June 8, 2022

Subject: **Response to Geotechnical Peer Review Comments Regarding  
2204-107-SUB1-PLANS**

Proposed Mercer Island Treehouse Residence  
5637 East Mercer Way  
Mercer Island, Washington

NORTH ELEVATION

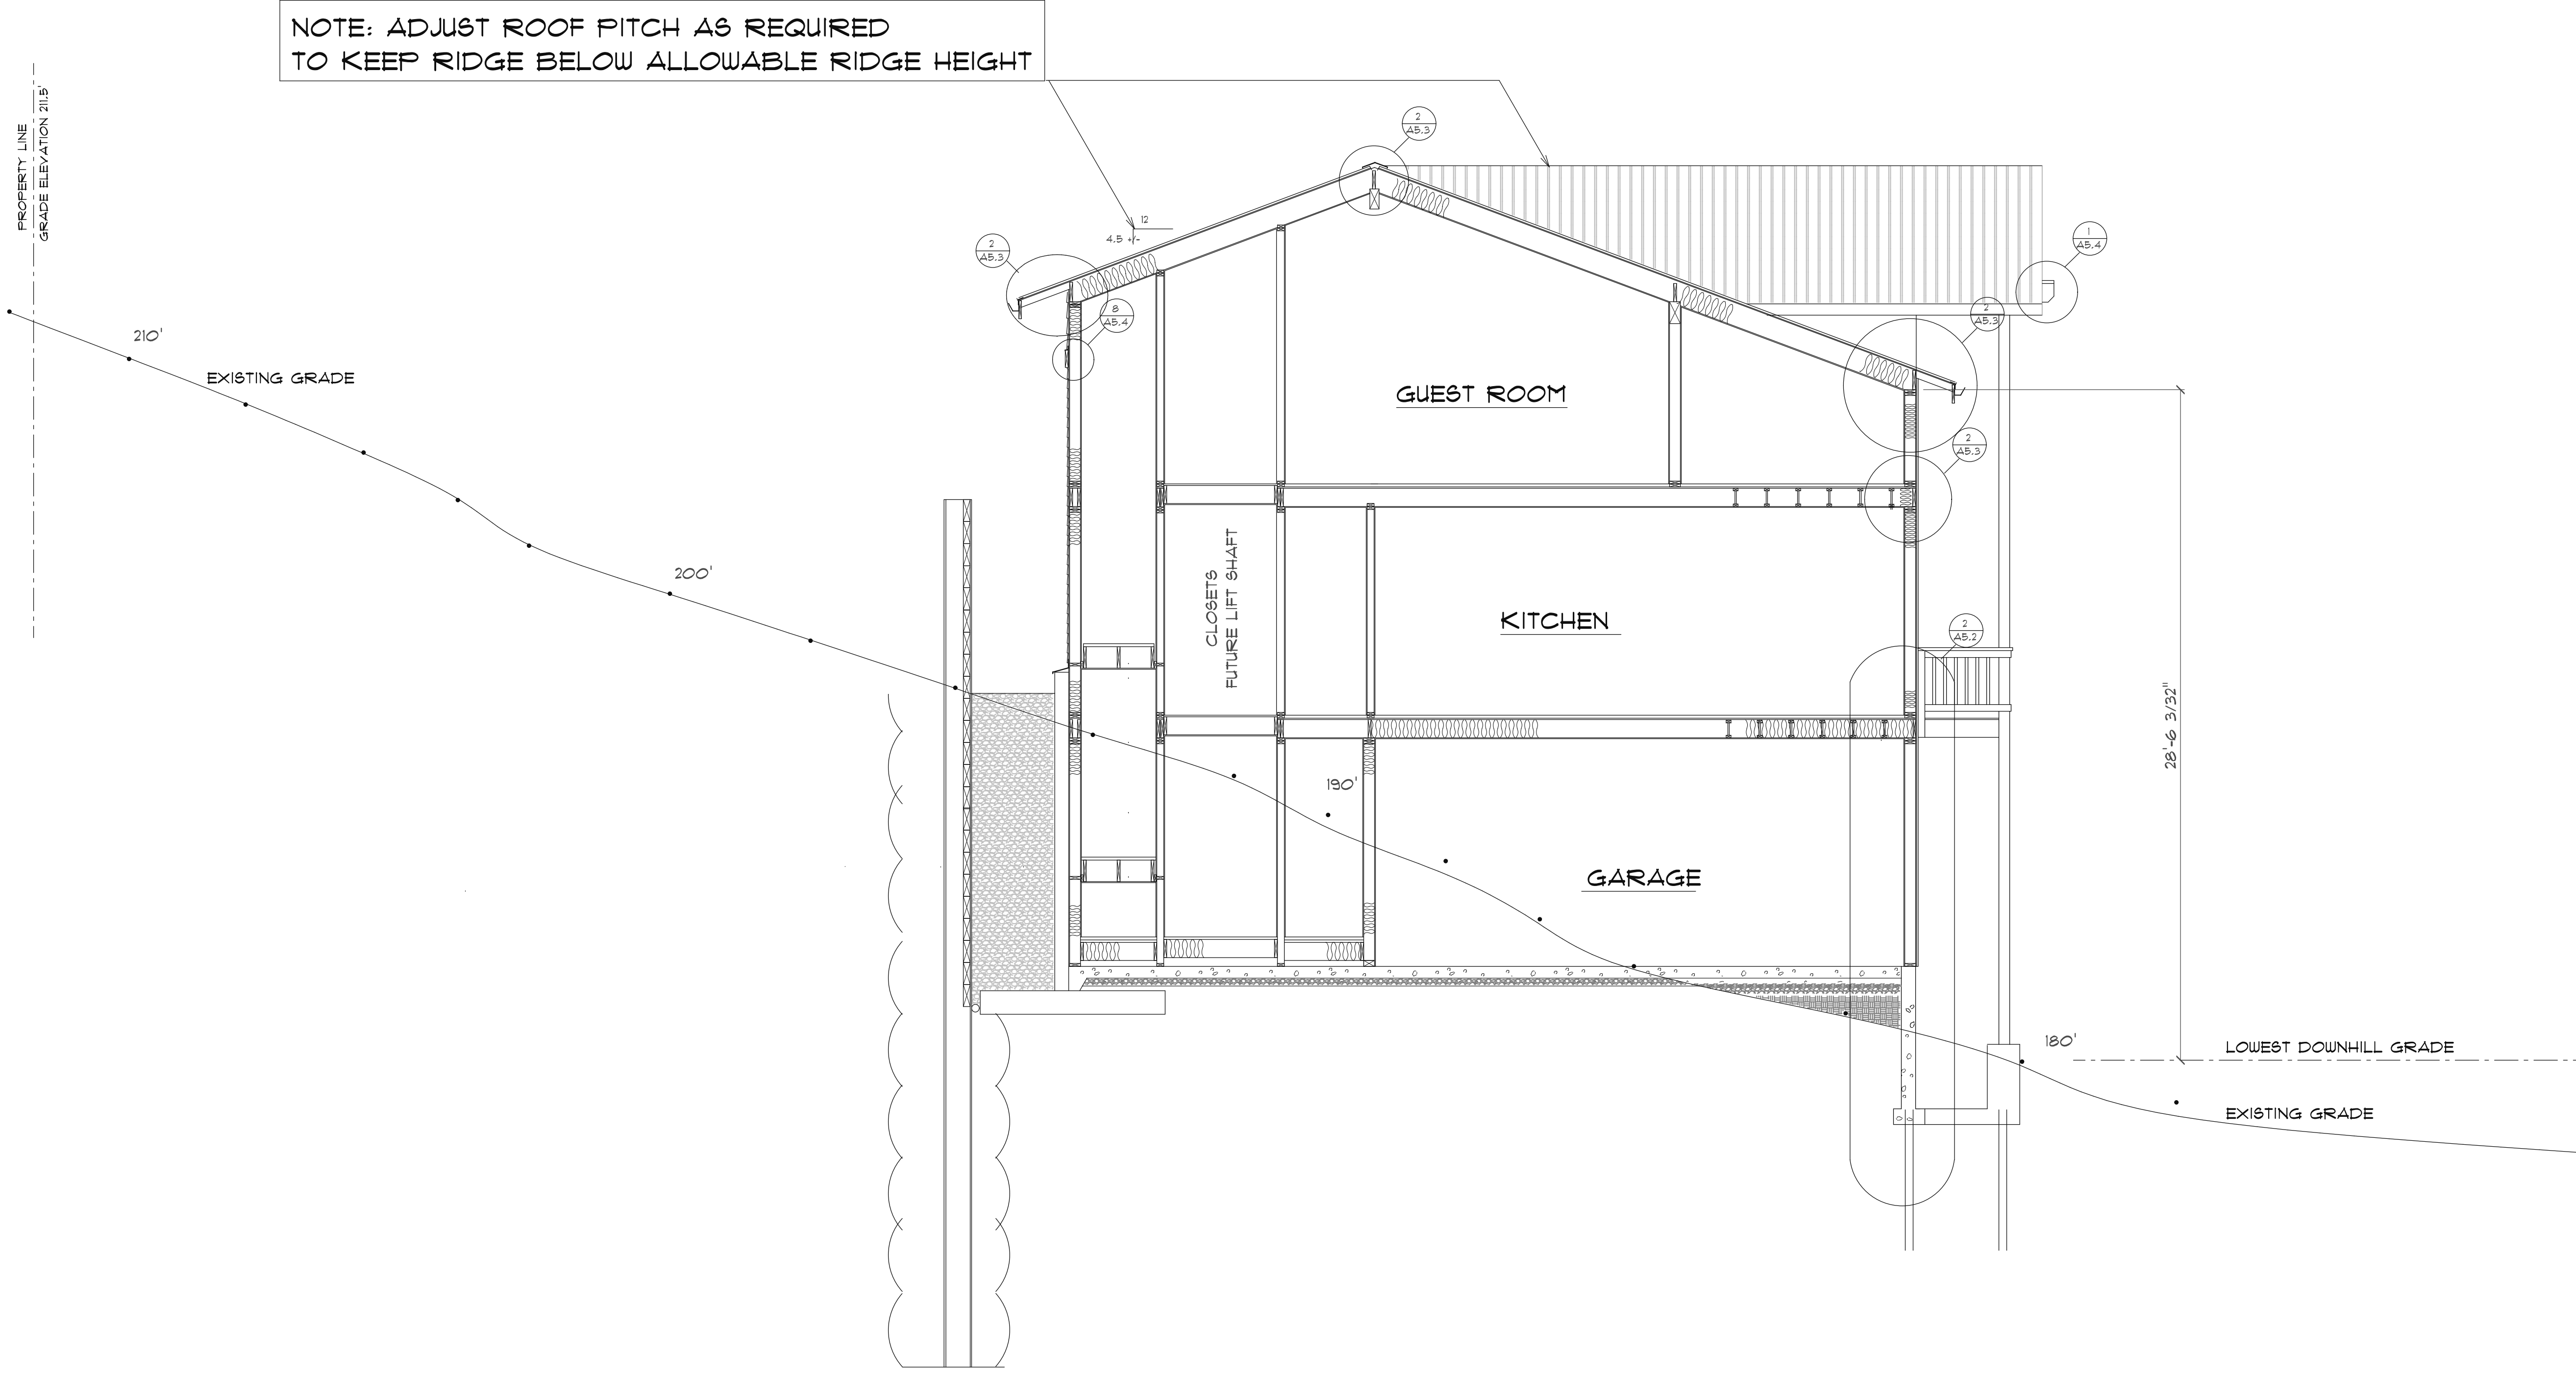
**Number: 1** *Isn't this retaining a fill? Wouldn't it be easier to provide drainage and piping behind the wall?*

**Response:** This wall shown on detail 3/P1.1 will be a backfilled soldier pile wall extending along the north side of the driveway. This is also depicted on the North Elevation on sheet A3.4. The driveway area behind the wall will be covered with pavement, preventing infiltration of precipitation into the backfill zone. Groundwater will be below the backfill zone, within the native soils. As a result, the potential for any significant amounts of subsurface water behind the above-grade portion of the wall is low. Drainage of any minimal amounts of water that may accumulate in the backfill could be handled either by a footing drain installed below the existing grade behind the soldier piles, or by installing weep holes through the base of the concrete wall facing. Two-inch-diameter weep holes on 6-foot spacing would be appropriate. If the soldier pile wall is constructed without a concrete facing, the treated timber can be backfilled with clean gravel, and any small amounts of subsurface water will simply weep out through the lagging.

P1.1
 SHORING/PIN PILE DETAILS

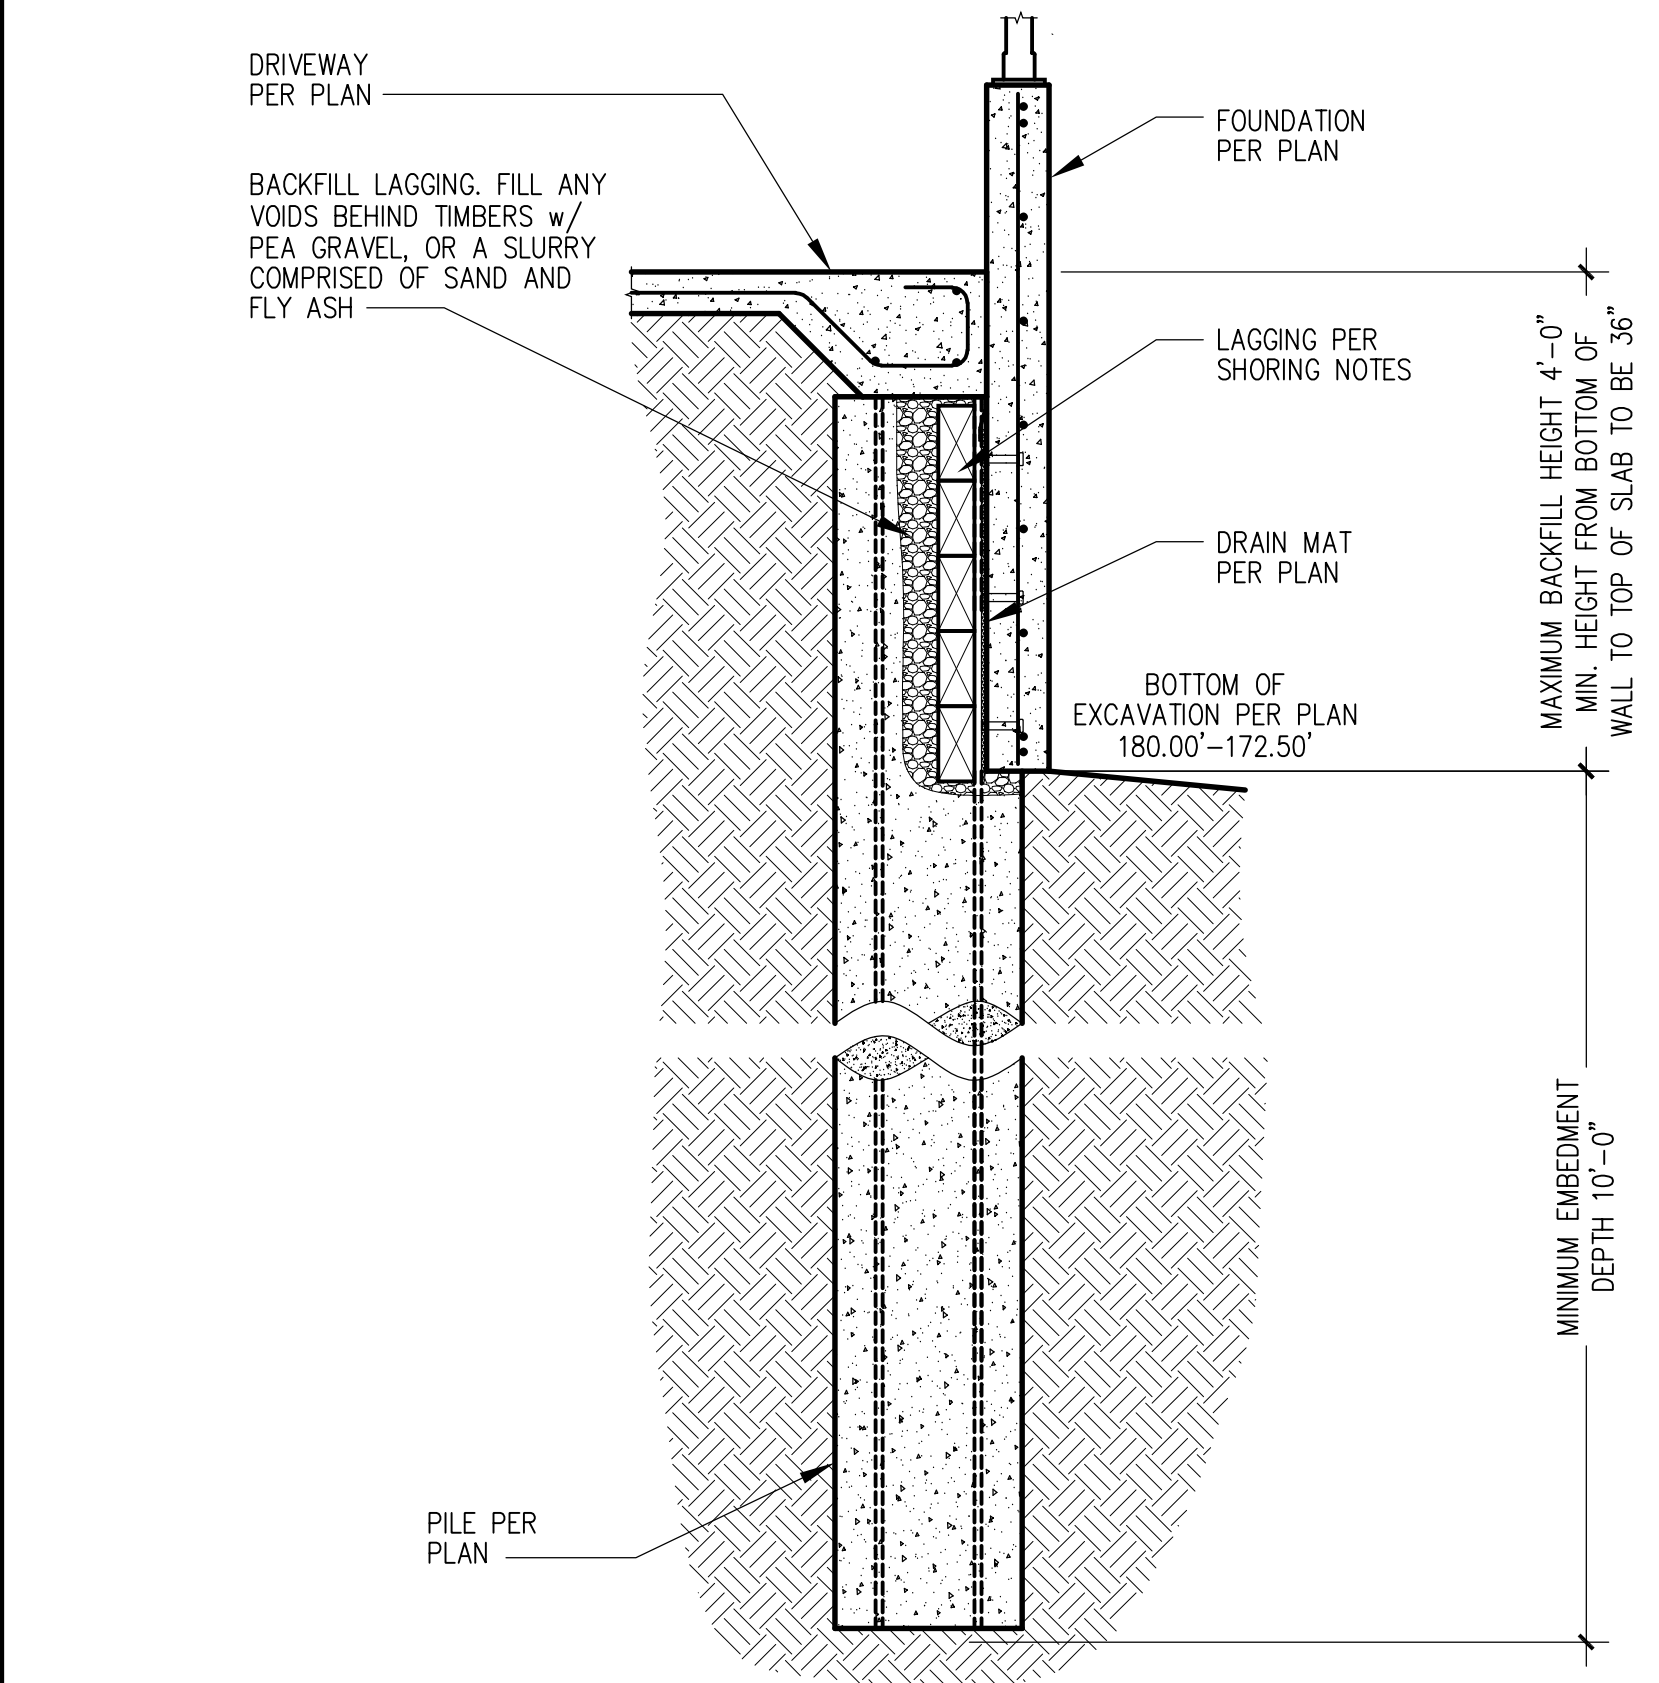
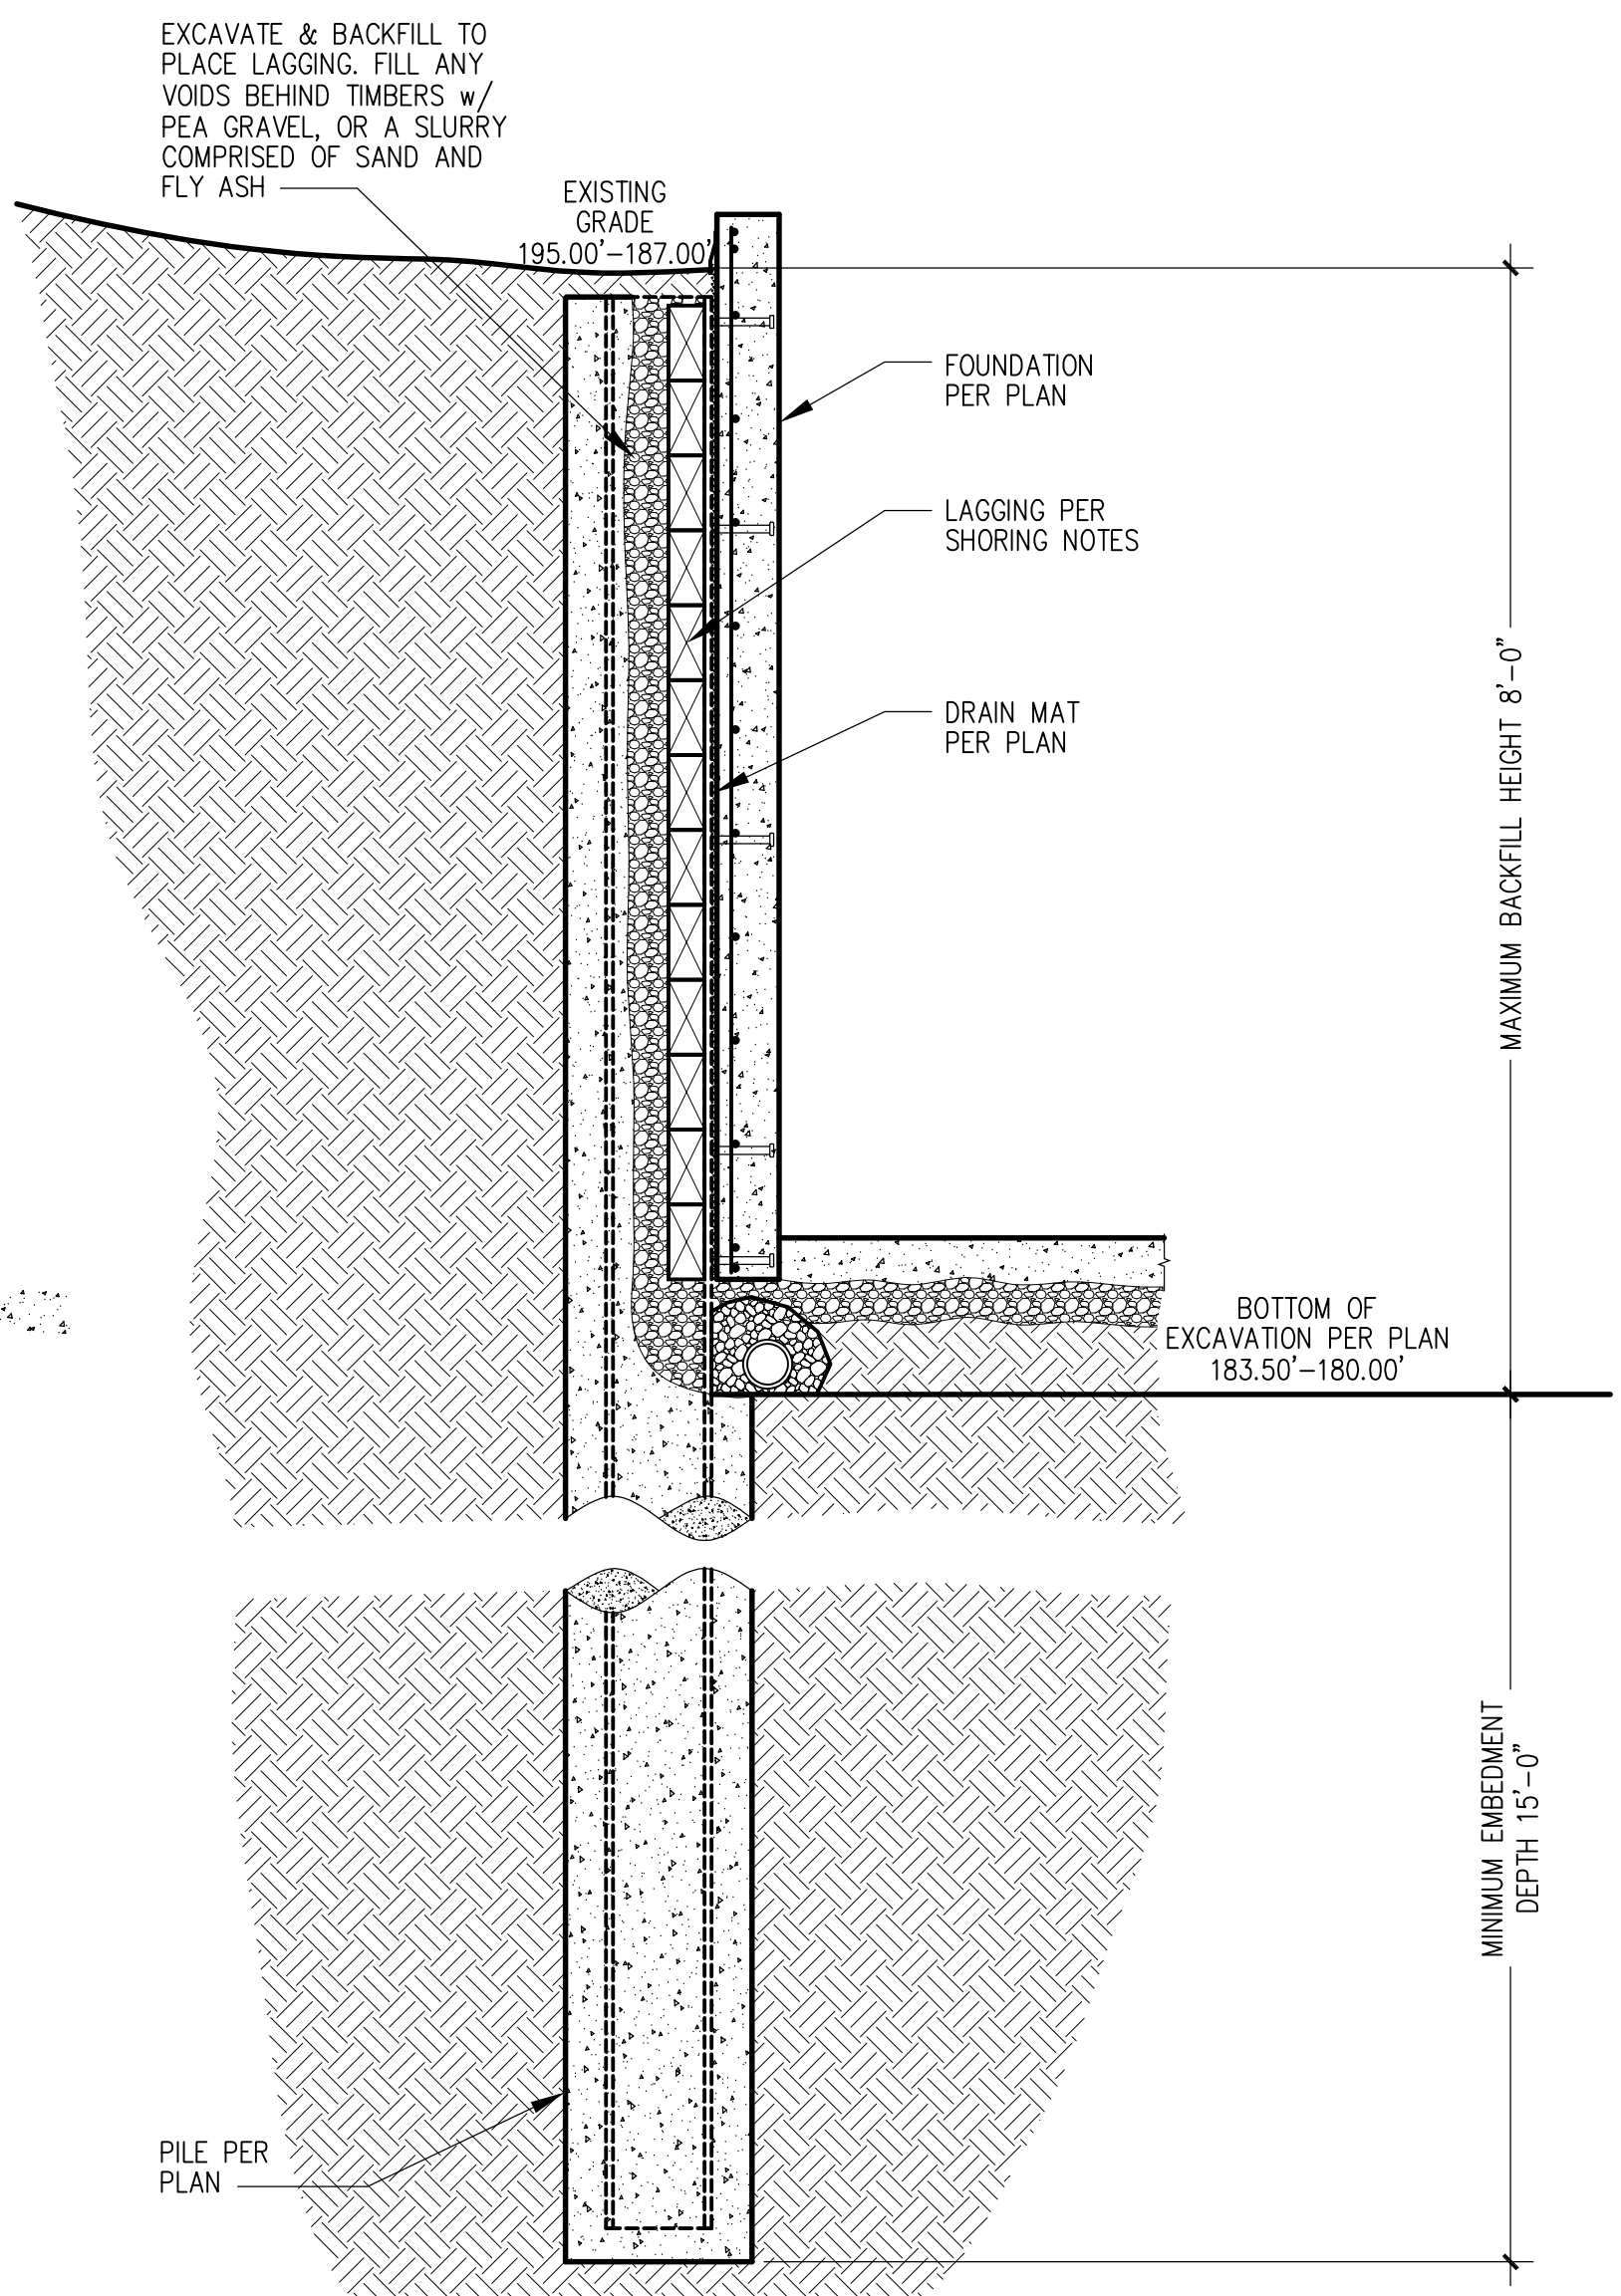
*Provide details on how this wall will be drained or design facing for hydrostatic pressures.*
